WaterNSW response to Amendment and Supplementary Information – Dendrobium Mine Extension Project (SSD 8194)

WaterNSW appreciates the opportunity to provide further comments on the Dendrobium Mine Extension Project (SSD 8194). WaterNSW has reviewed the supplementary information (dated 7 September 2020), amended project report (dated August 2020) and South32's response to WaterNSW's residual comments (dated 15 June 2020) and outlines its key issues below.

Figure 6-3B – Variation in Inferred Height of Fracturing using the Tammetta Equation

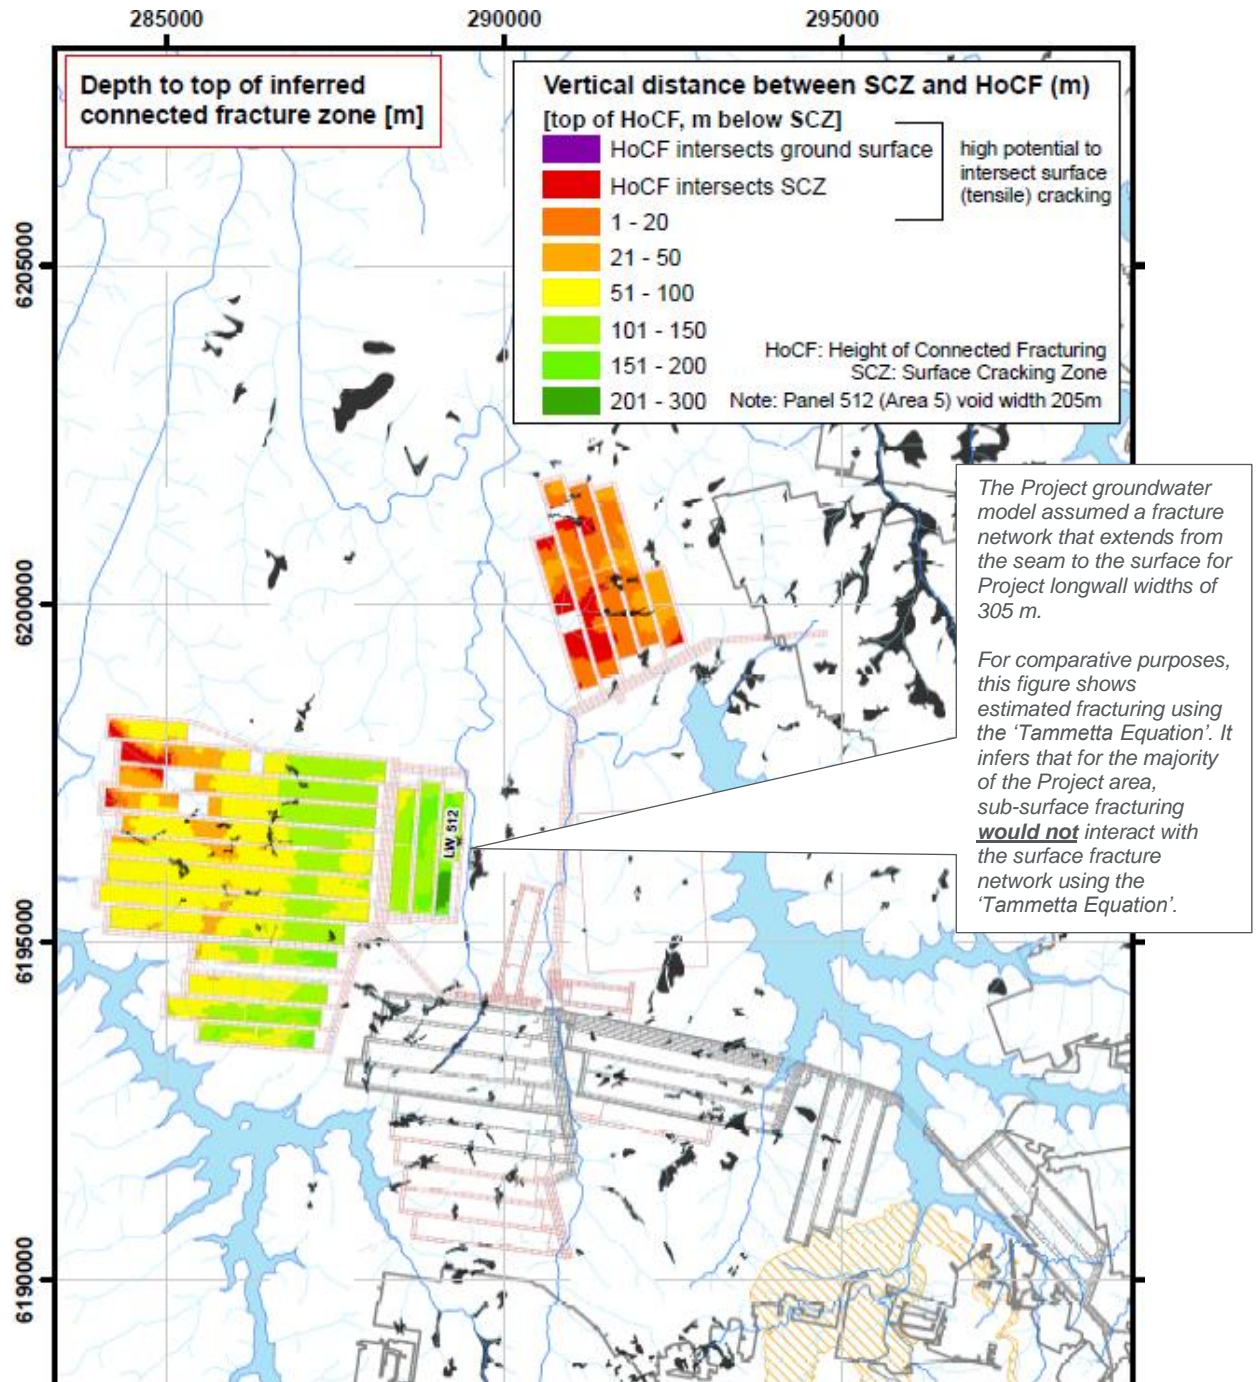
WaterNSW acknowledges that any such mine design changes can reduce economic benefits, however a significant reduction in environmental impacts may be achievable with relatively minor changes. In that regard, WaterNSW refers to Figure 6-3B of the RTS report titled "*Spatial variation in inferred height of connected fracturing Rev. A, dated 04/09/2019*" (based on the Tammetta equation). This figure indicates that there is already a predicted gap between the surface cracking zone and subsurface fractured zone in many areas of the proposed mine.

- consider an alternative mine design incorporating the following changes:
 - a reduction in the lengths of longwalls in the north-western corner of Area 5 (e.g. longwalls 508A and 509) and at the eastern extent of Area 5 (e.g. longwall 510)
 - minor to moderate reductions in longwall widths in Area 5 to further increase the distance between the surface cracking zone and subsurface fractured zone, and
 - moderate reductions in longwall widths in Area 6 to prevent surface to seam cracking and increase the distance between the surface cracking zone and subsurface fractured zone, and
- provide revised surface water loss predictions for any alternative mine designs.
